**RE: 1203 Coal Ave SE  
Grading & Drainage Plan  
Engineer's Stamp Date: 2/27/26  
Hydrology File: K15D011  
Case # HYDR-2026-00076**

Based upon the information provided in your submittal received 2/27/2026, the Grading & Drainage Plan **is not approved** for Grading Permit or Building Permit. The following comments need to be addressed for approval of the above referenced project.

ENGINEER'S SEAL	LOT 7-A-1 THRU 7-A-4 BLK 32 TERRACE ADD 1203 COAL AVENUE SE GRADING AND DRAINAGE PLAN	DRAWN BY DEM
		DATE 2-24-26
	SHEET # C1 JOB #	SHEET # C1 JOB #
DAVID SOULE P.E. #14522 3/3/26		Rio Grande Engineering P.O. BOX 53304 ALBUQUERQUE, NM 87199 (505) 321-8099

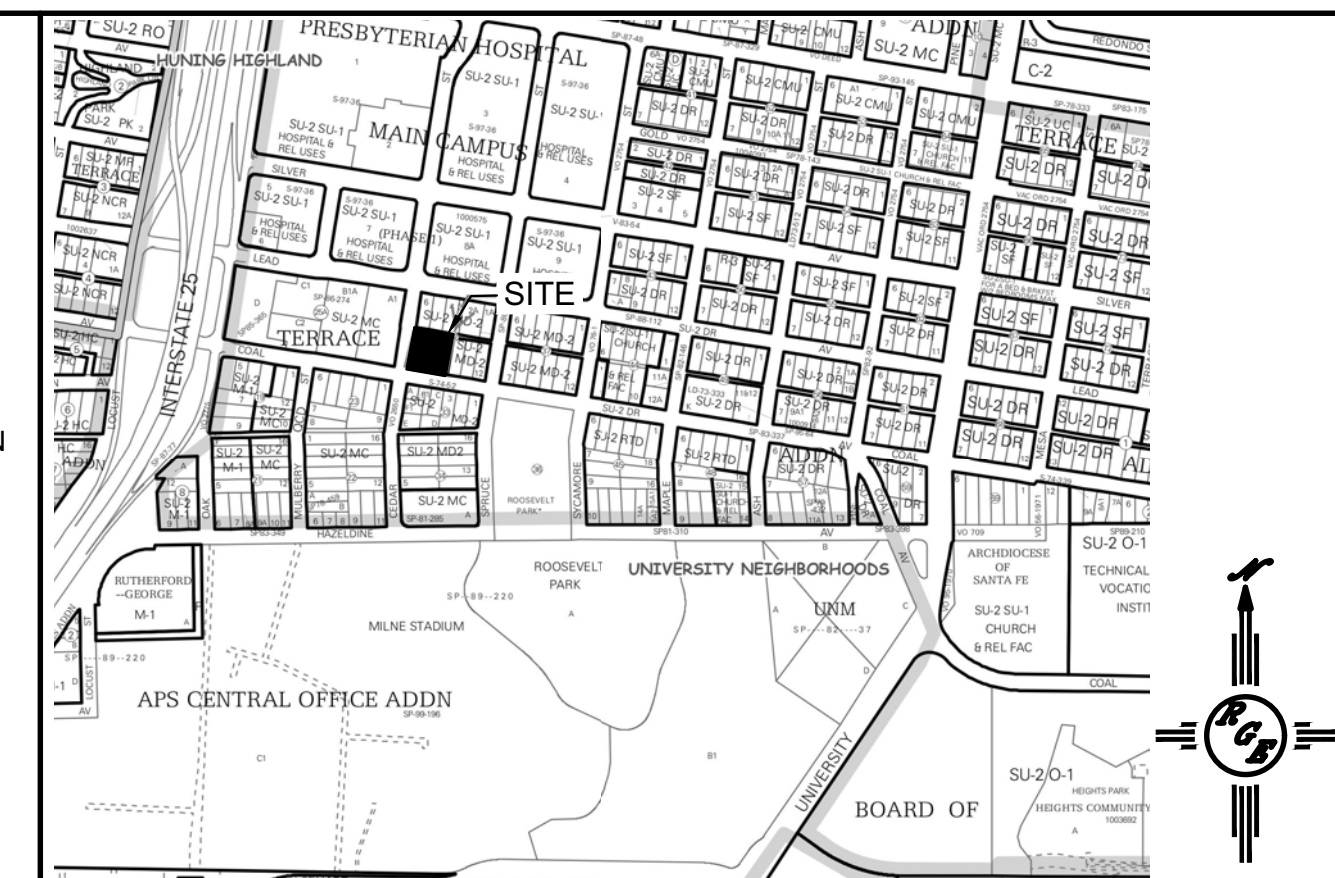
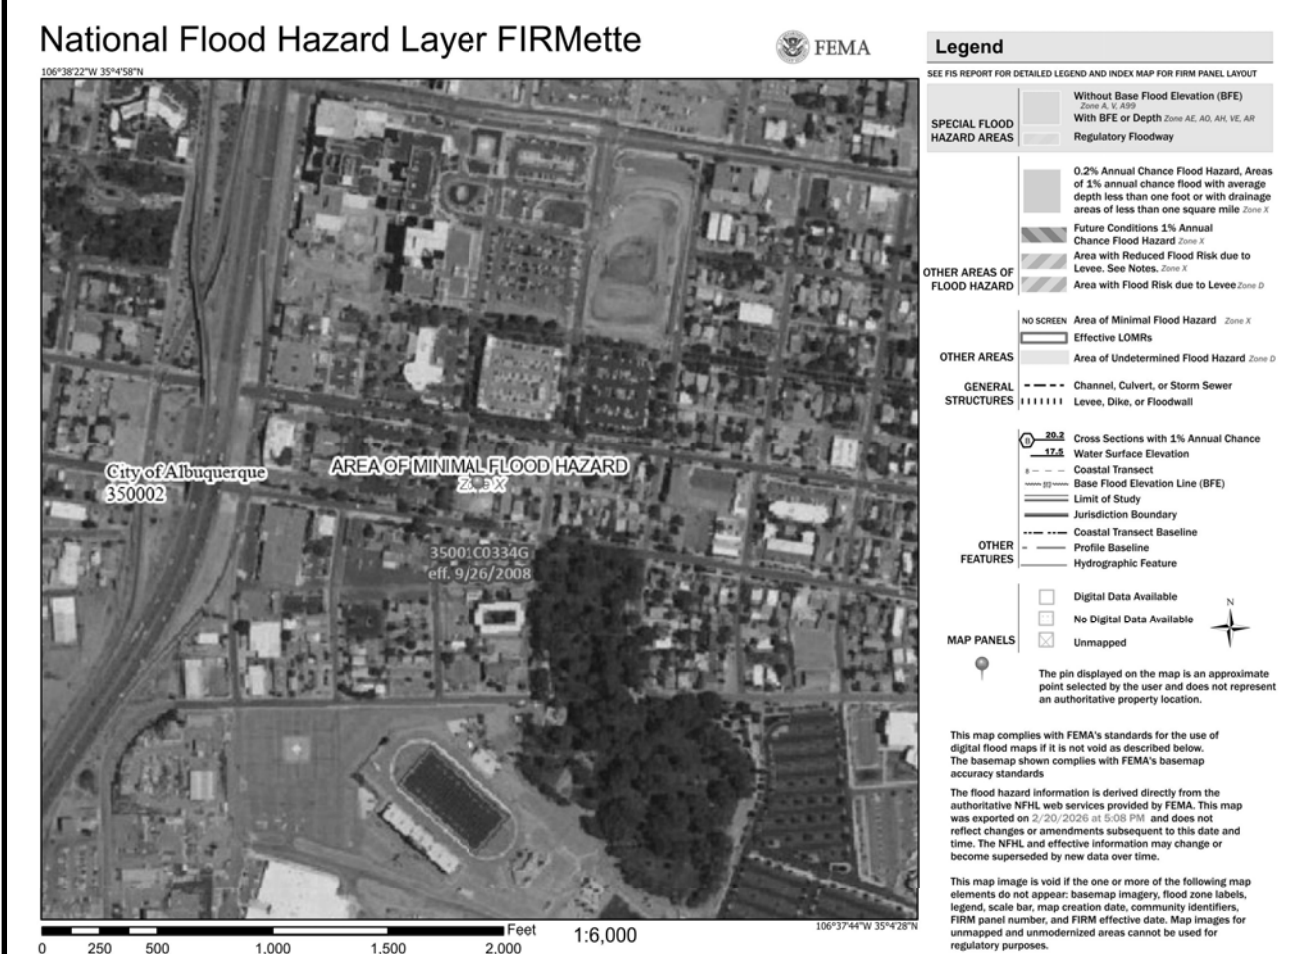
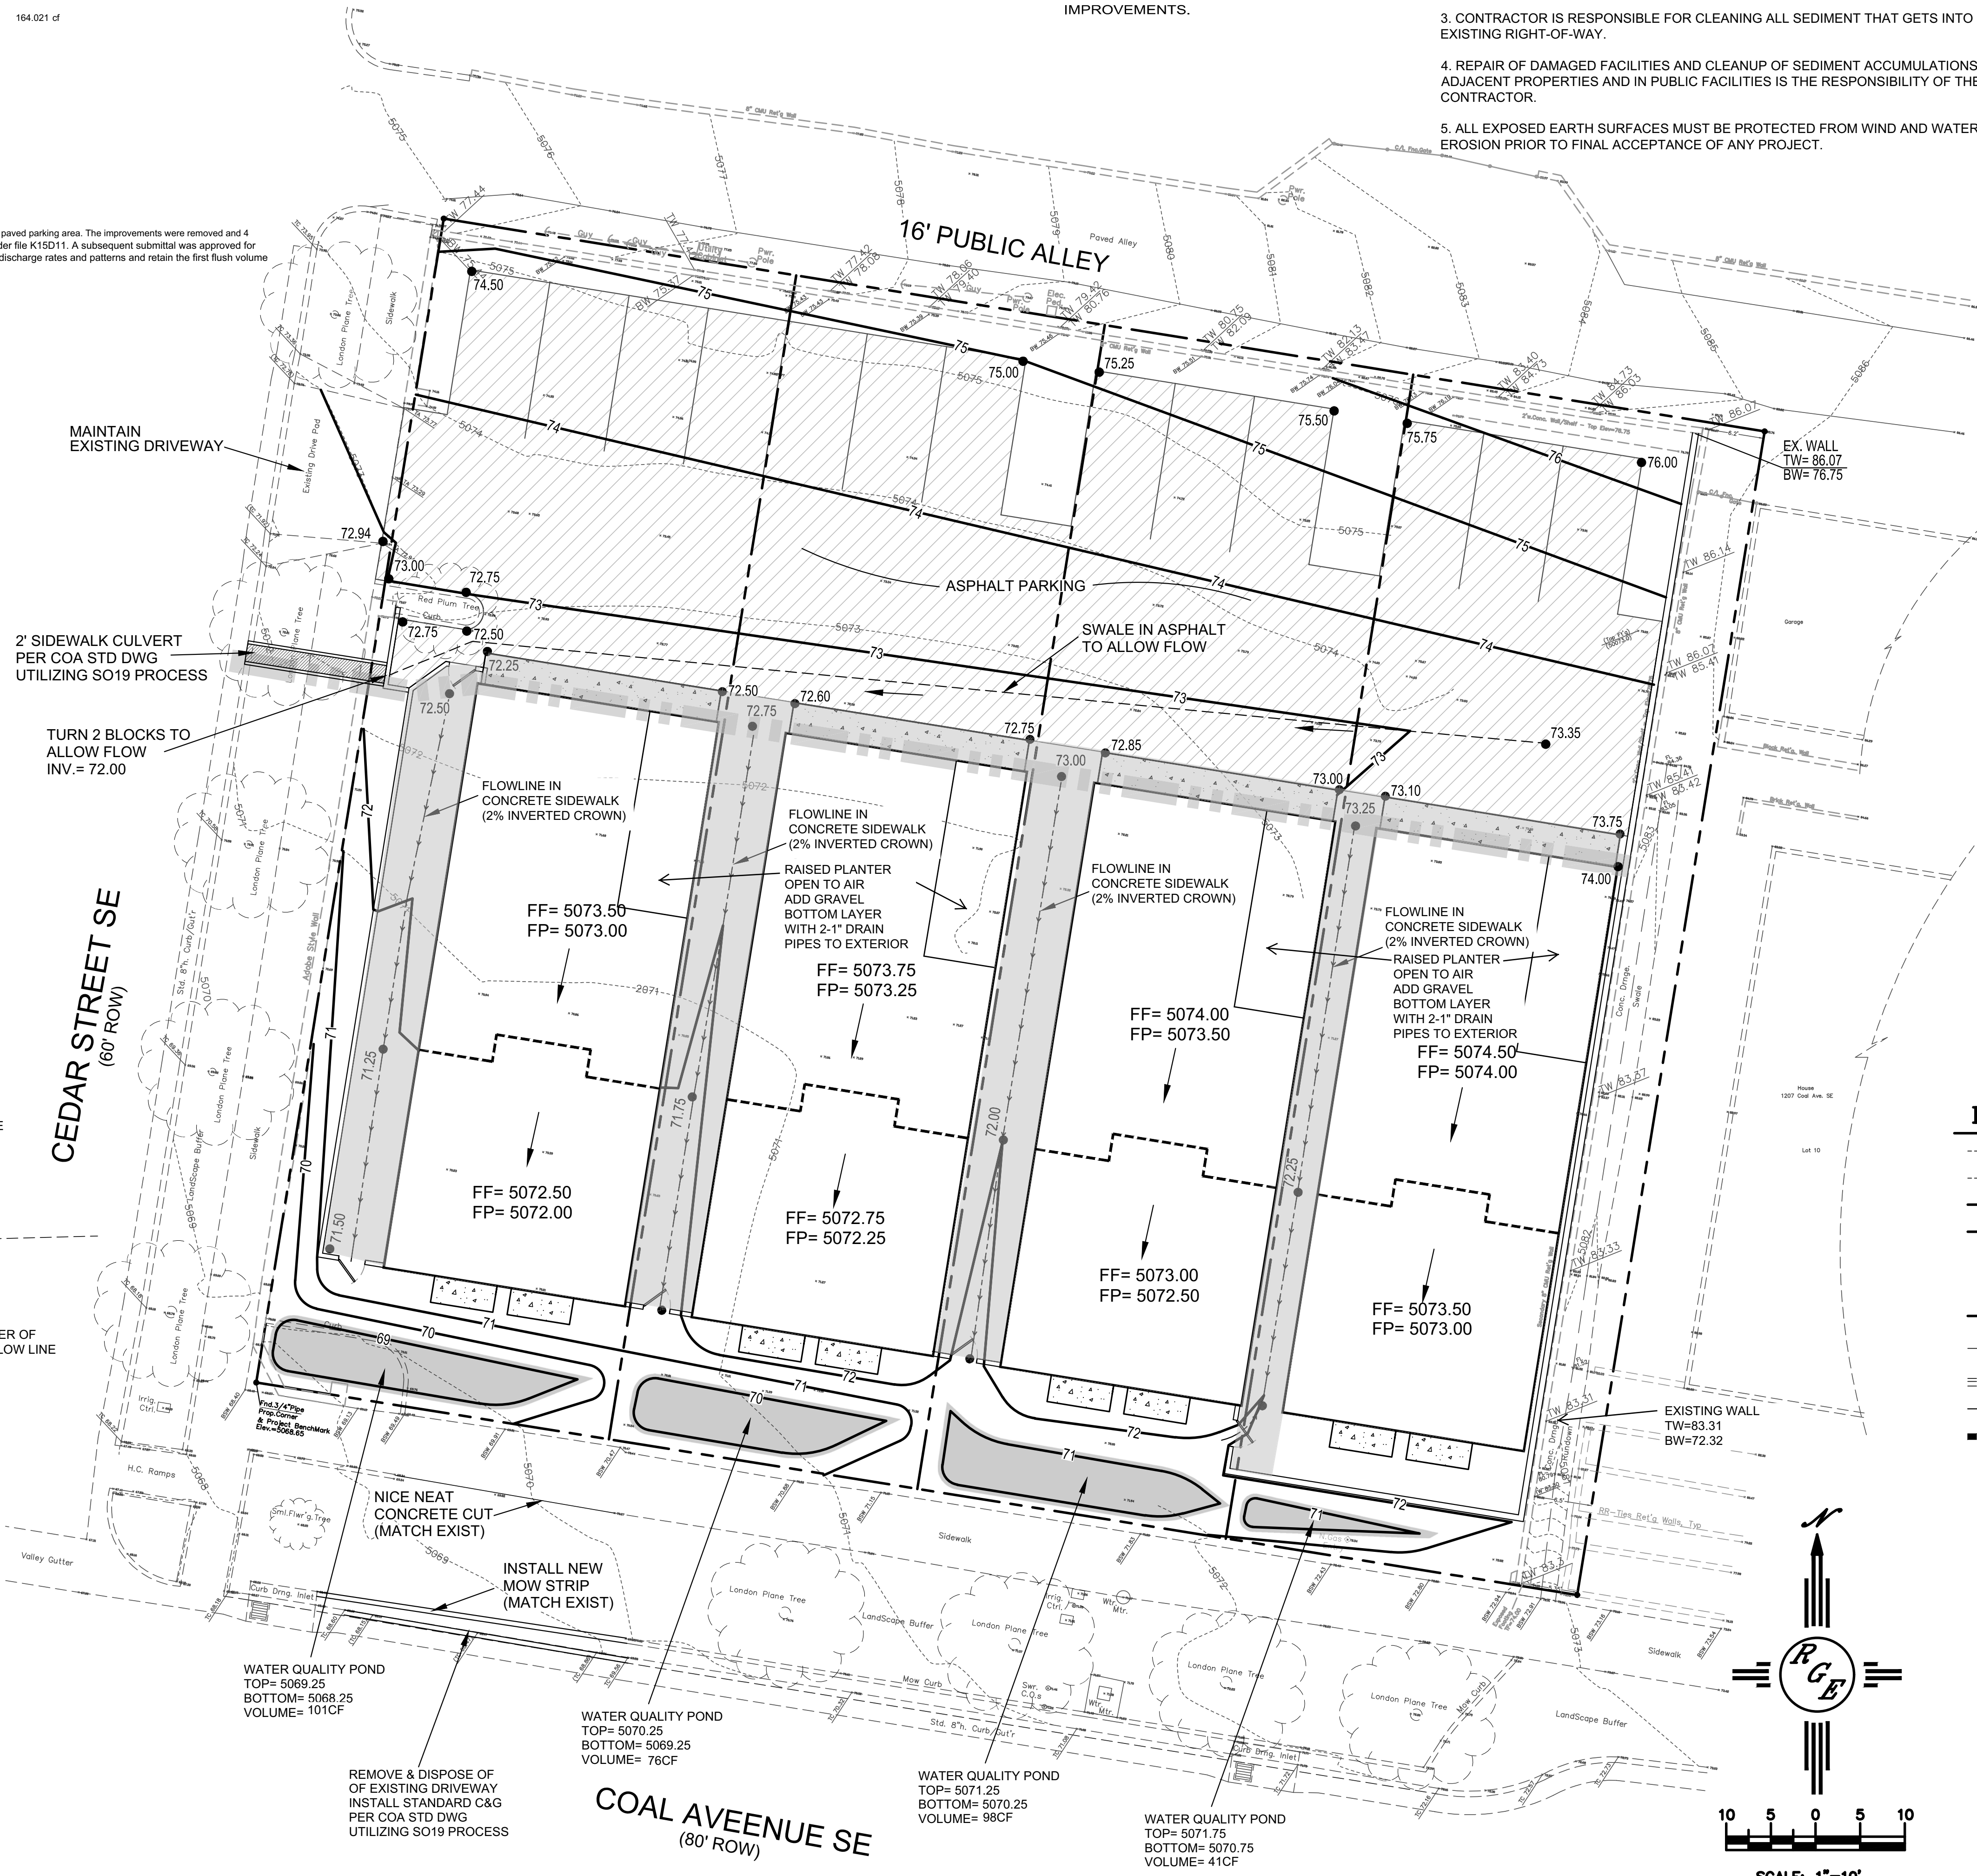
1. An SO-19 Permit will be required and should be included on the request. Please include the [standard SO-19](#) notes on the grading plan.
2. Please provide the FIRM Map and floodplain note with effective date.
3. Provide the existing and proposed grades on both sides of the proposed retaining walls.
